From: Mark de Pulford <[REDACTED]>
Sent: 08 April 2019 10:48
To: Manston Airport <[REDACTED]>; Manston Airport
<ManstonAirport@planninginspectorate.gov.uk>
Cc: [REDACTED]
Subject: 2nd ExA QUESTIONS - NOISE

The enquiry is urgent in the light of the 2nd set of ExA questions (Ns.2) Those questions appear to have left unexamined or muddled, some significant, fact-based concerns about the applicant's methodology and metrics:

Fig. 1 747-400 approaching from the west – 85, 90 and 95dB(A) SEL footprints

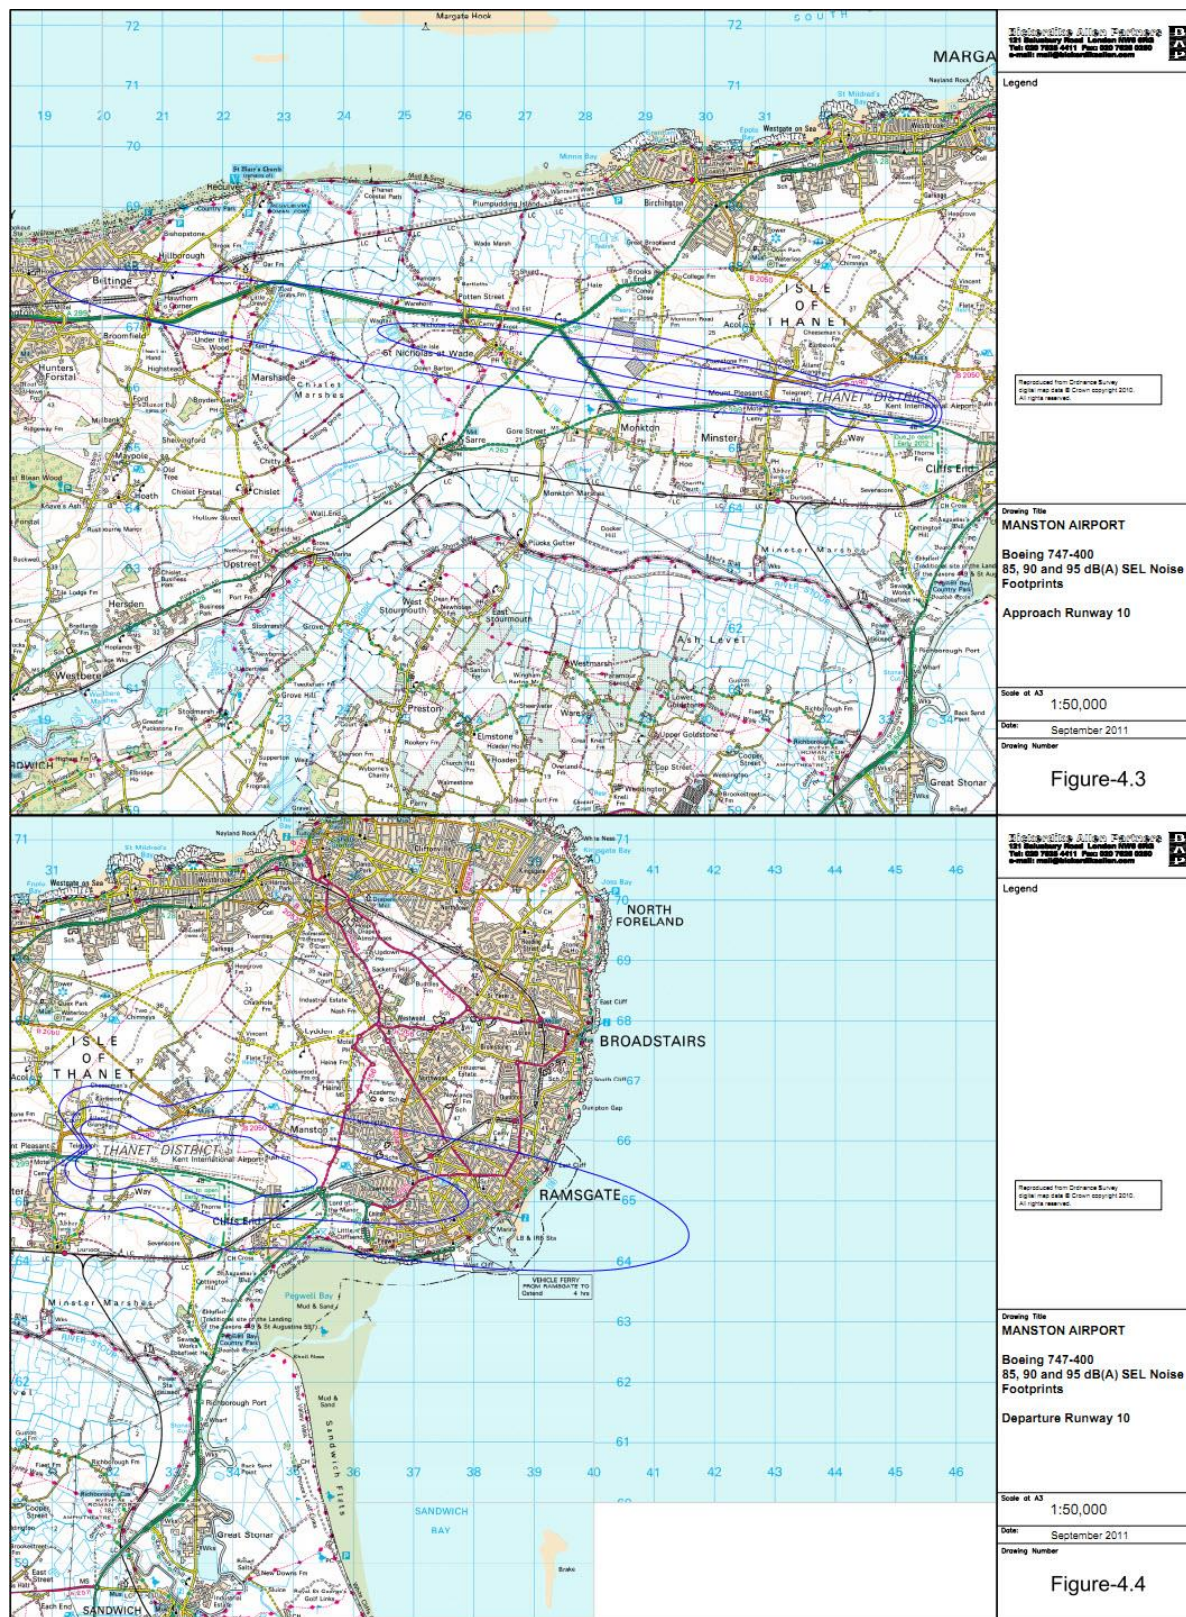
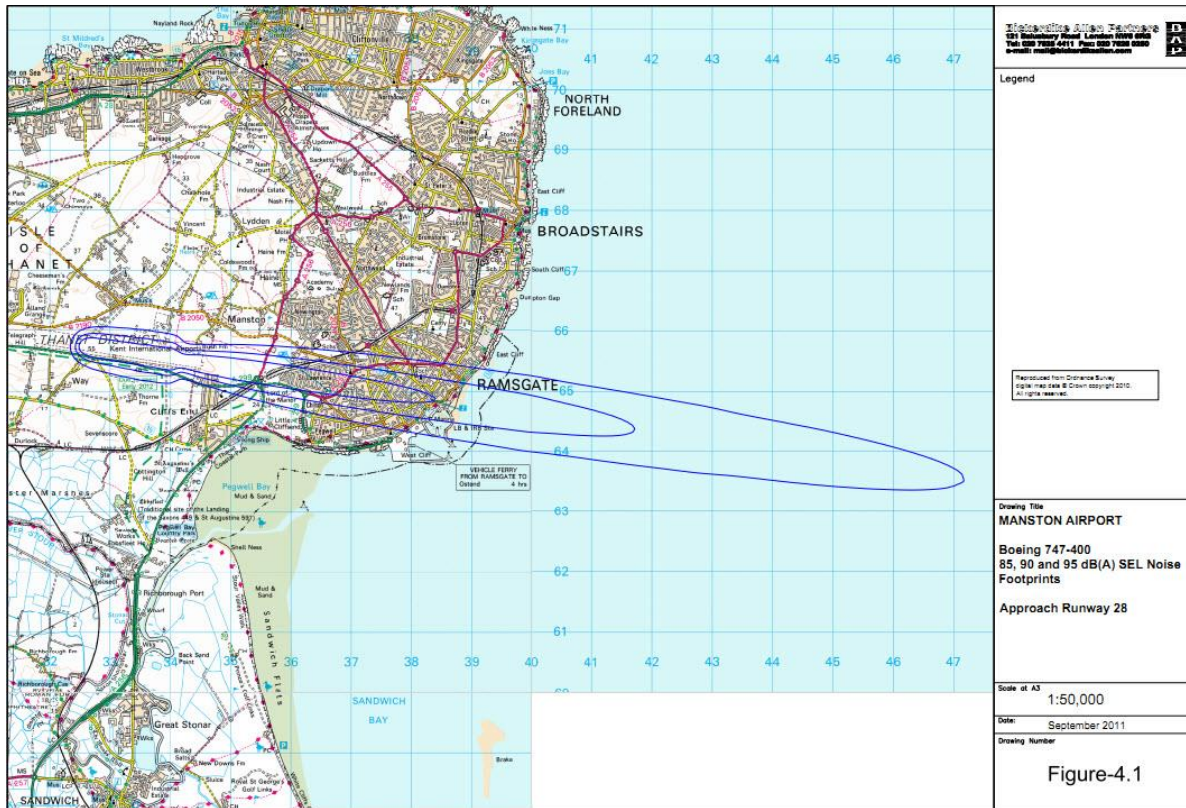
1. Noise contours contradicted by official records from 747-400s operating from Manston, and expert analysis. A lot of submitted data on this and considerable public testimony. Why no questions?

Figure 12.6
Aircraft noise - daytime $L_{Aeq,16hr}$
contours - year of forecast maximum
capacity

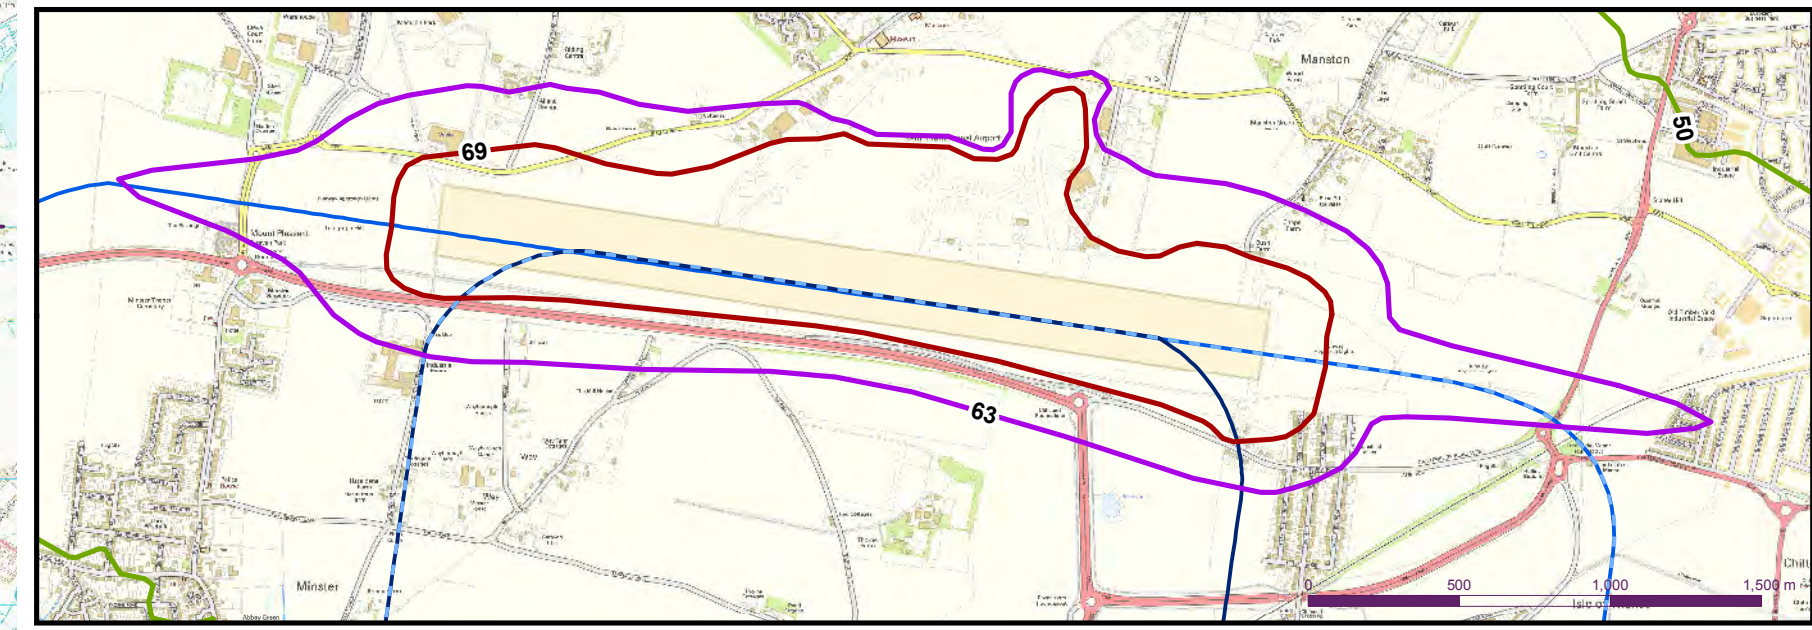
5. Continuing reliance on equalised/averaged noise calculations masks the clarity and reality of impact analysis required by the amended parent EU Directive. The issue is especially pertinent to this application given the existing zero Manston aviation baseline.
